## Local Policing Support Team

**RE: Land South of Water Lane Angmering**

Thank you for your correspondence of the 4<sup>th</sup> August 2020, advising me of a planning application for Approval of reserved matters following outline consent A/99/17/OUT for 175 No dwellings & associated infrastructure. This application may affect the setting of a listed building, may affect the character & appearance of the Angmering Conservation Area & falls within Strategic Site SD9, CIL Zone 1 (Zero Rated) at the above location, for which you seek advice from a crime prevention viewpoint.

3 Super LEAP & Playable Green Spaces with Landscaped LAP

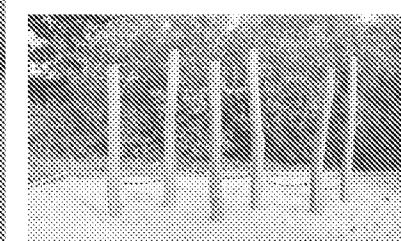
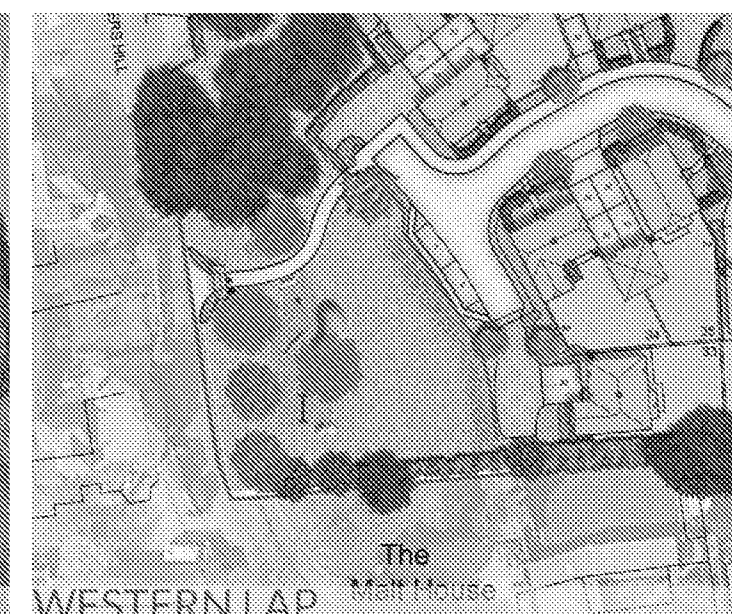
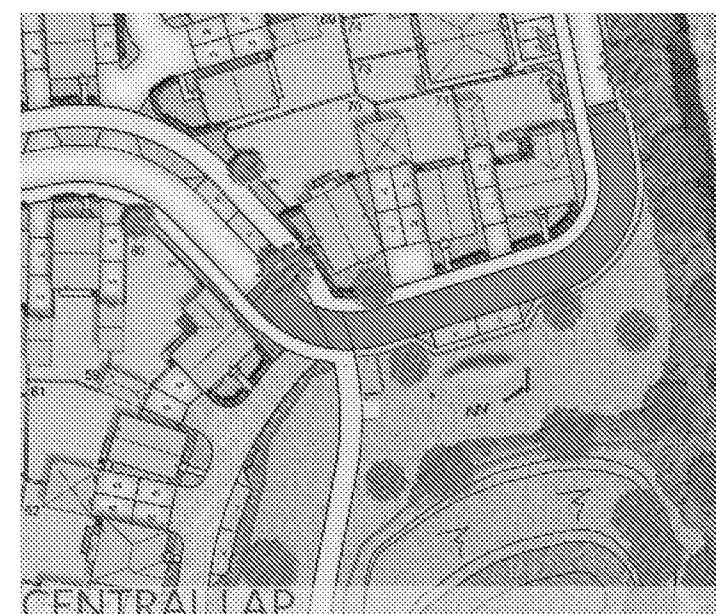
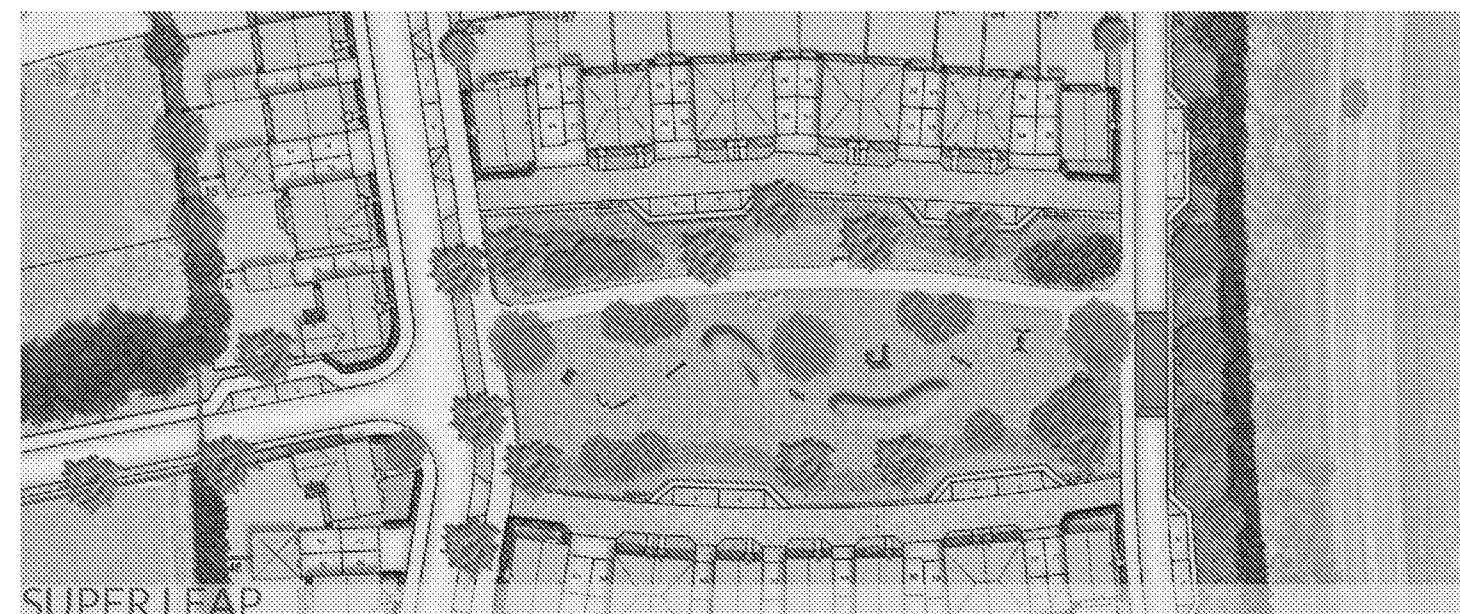
With regards to the LEAP and LAPS communal areas such as playgrounds, toddler play areas and seating facilities have the potential to generate crime, the fear of crime and anti-social behaviour. I am pleased to note that they have been designed to allow natural surveillance from nearby dwellings.

I would ask that when consideration is given to the eventual locations of the LEAP and LAPS that they are surrounded with railings with self-closing gates to provide a dog free environment.

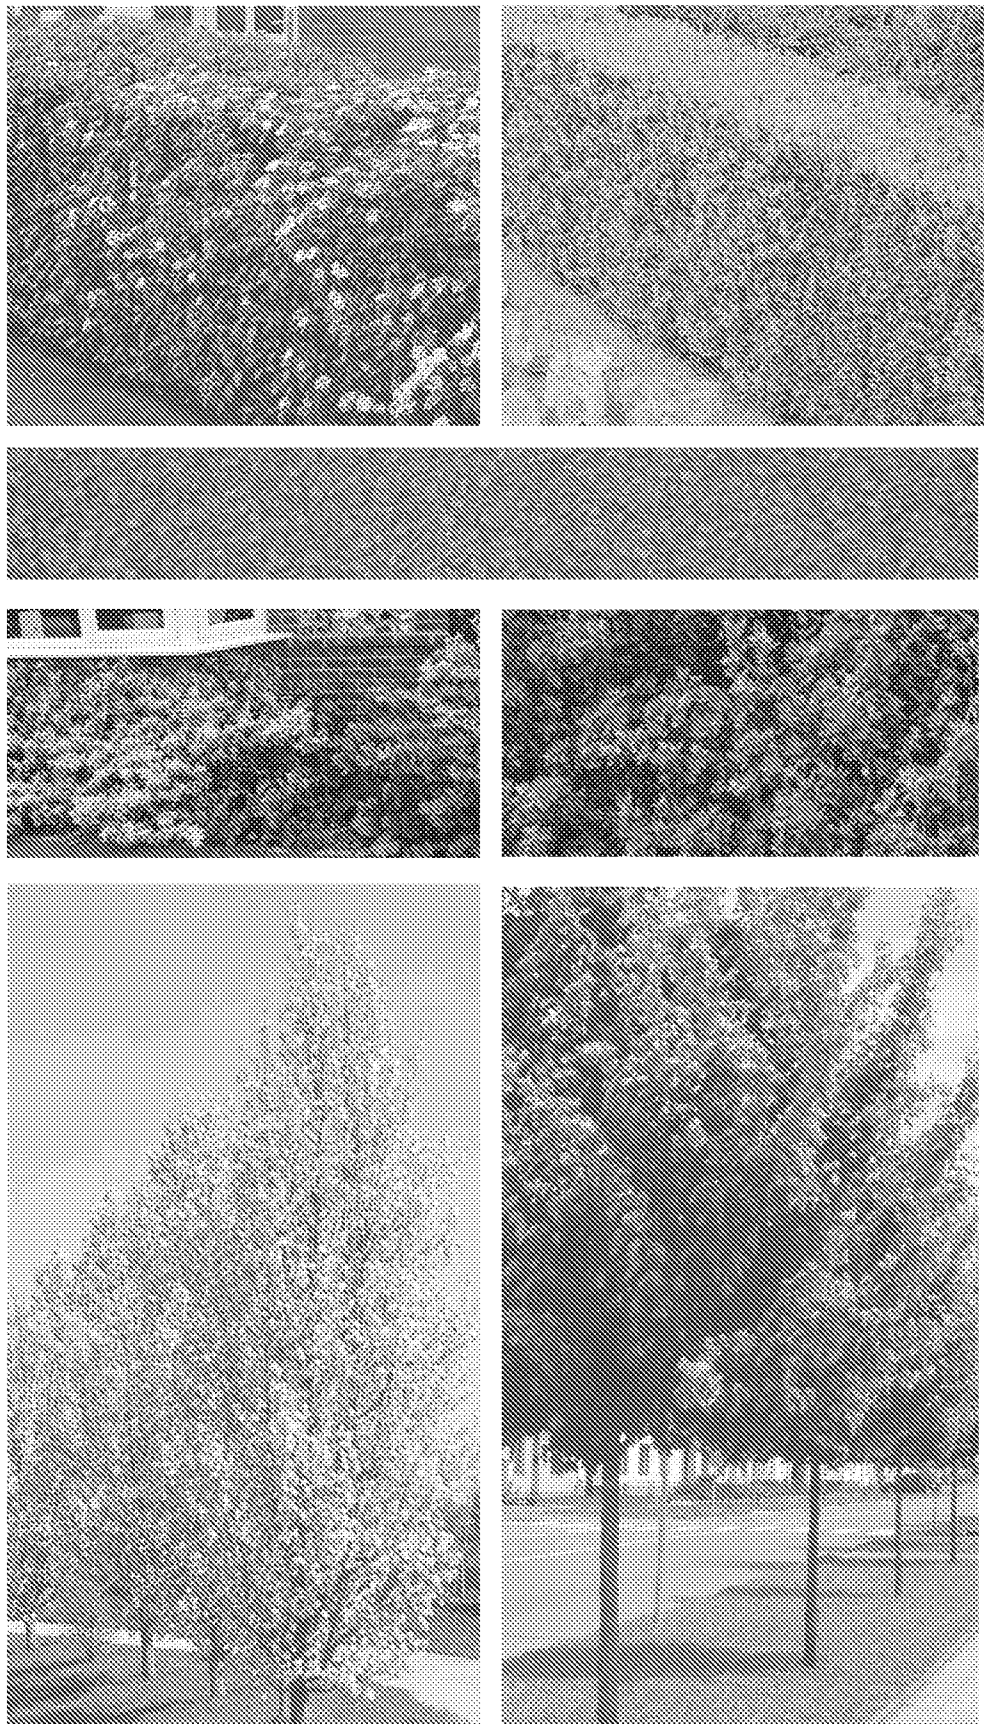
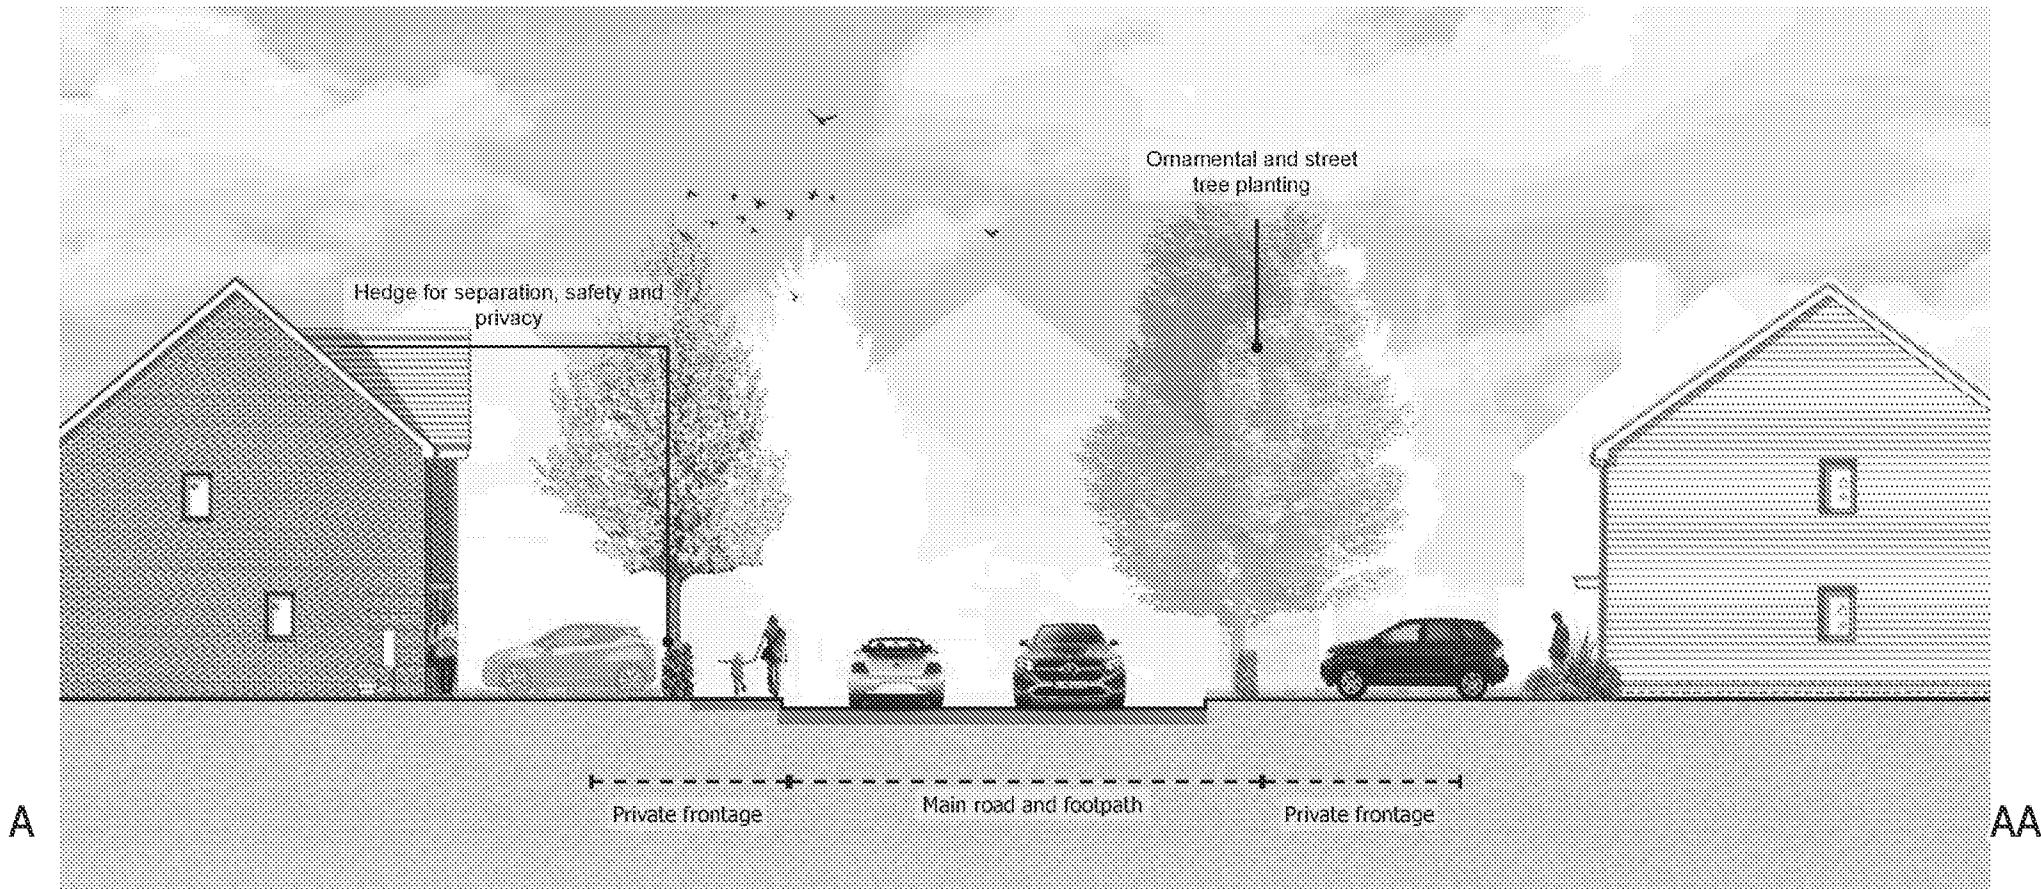
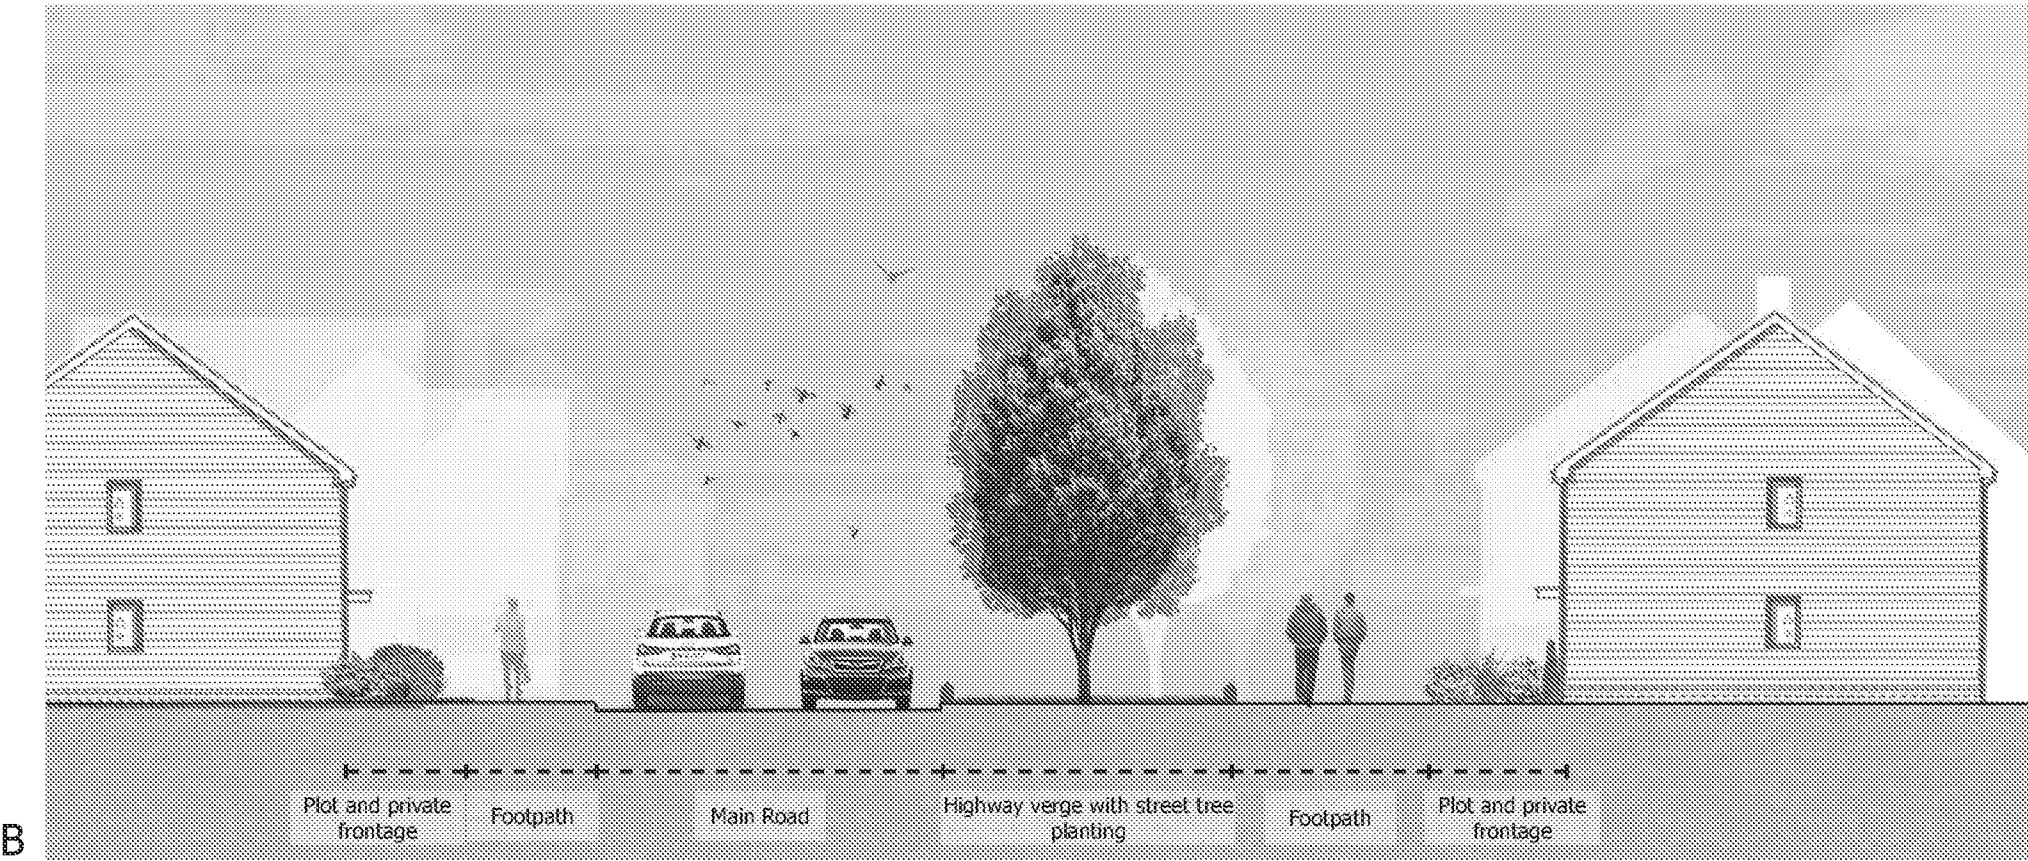
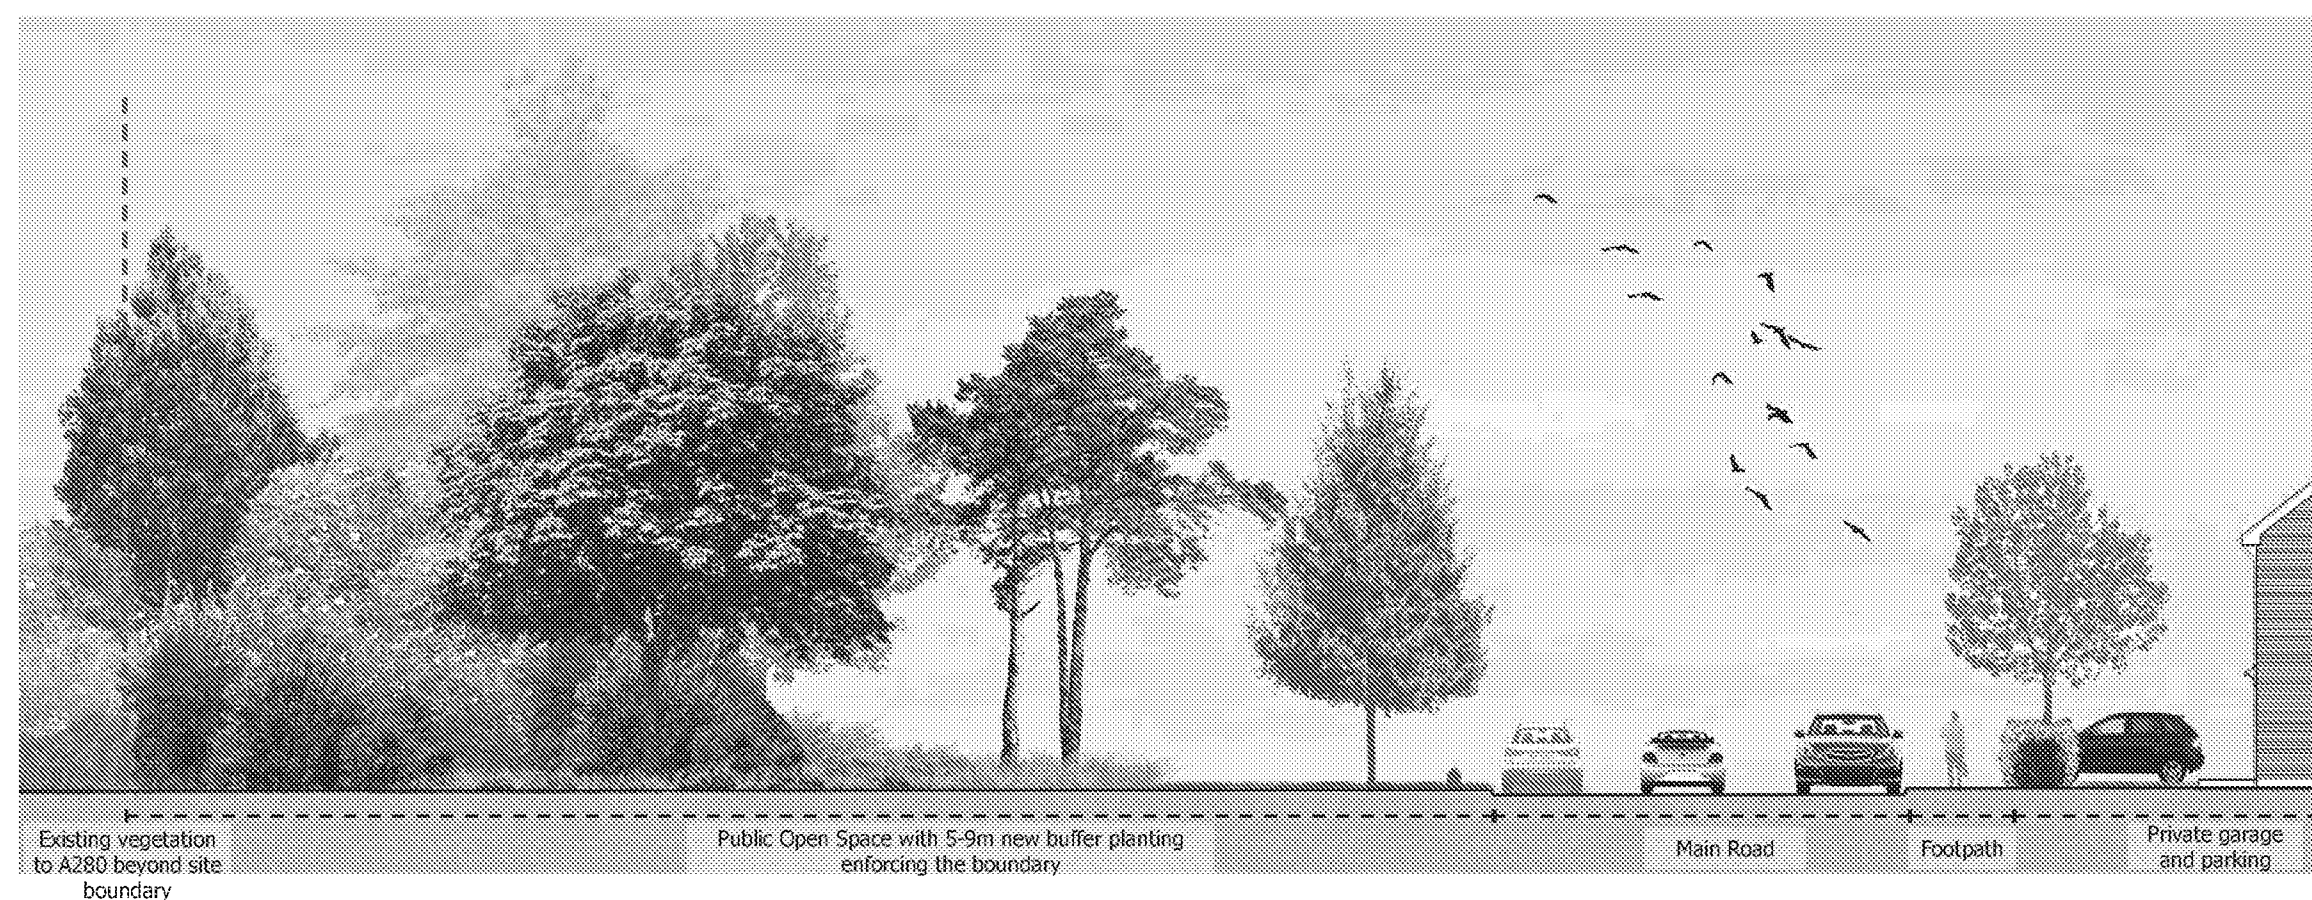
With regards to the proposed landscaping I recommend that ground planting should not be higher than 1 metre with tree canopies no lower than 2 metres. This arrangement provides a window of observation throughout the area.

Courtyard Parking

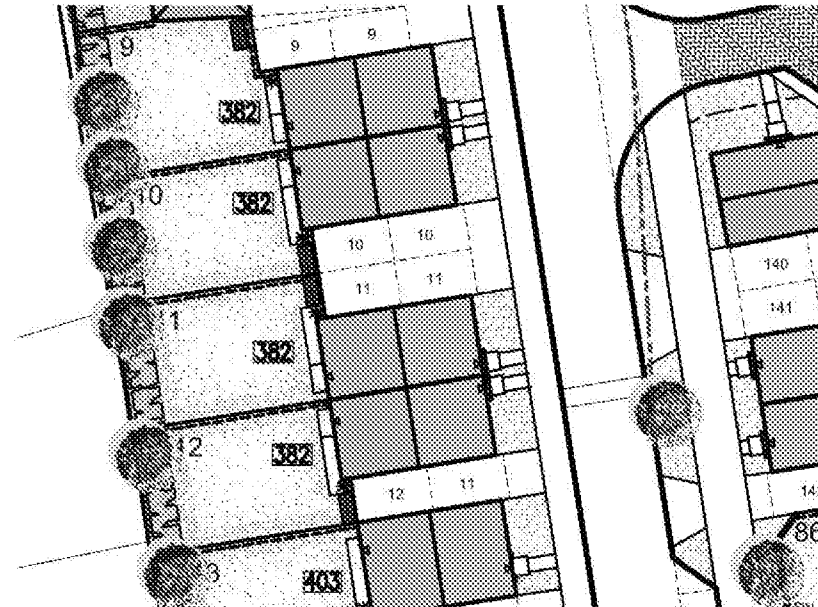
With regards to the communal parking areas it is important that they must be within view of an active room within the property. An active room is where there is direct and visual connection between the room and the street or the car parking area. Such visual connections can be expected from rooms such as kitchens and living rooms, but not from bedrooms and bathrooms.
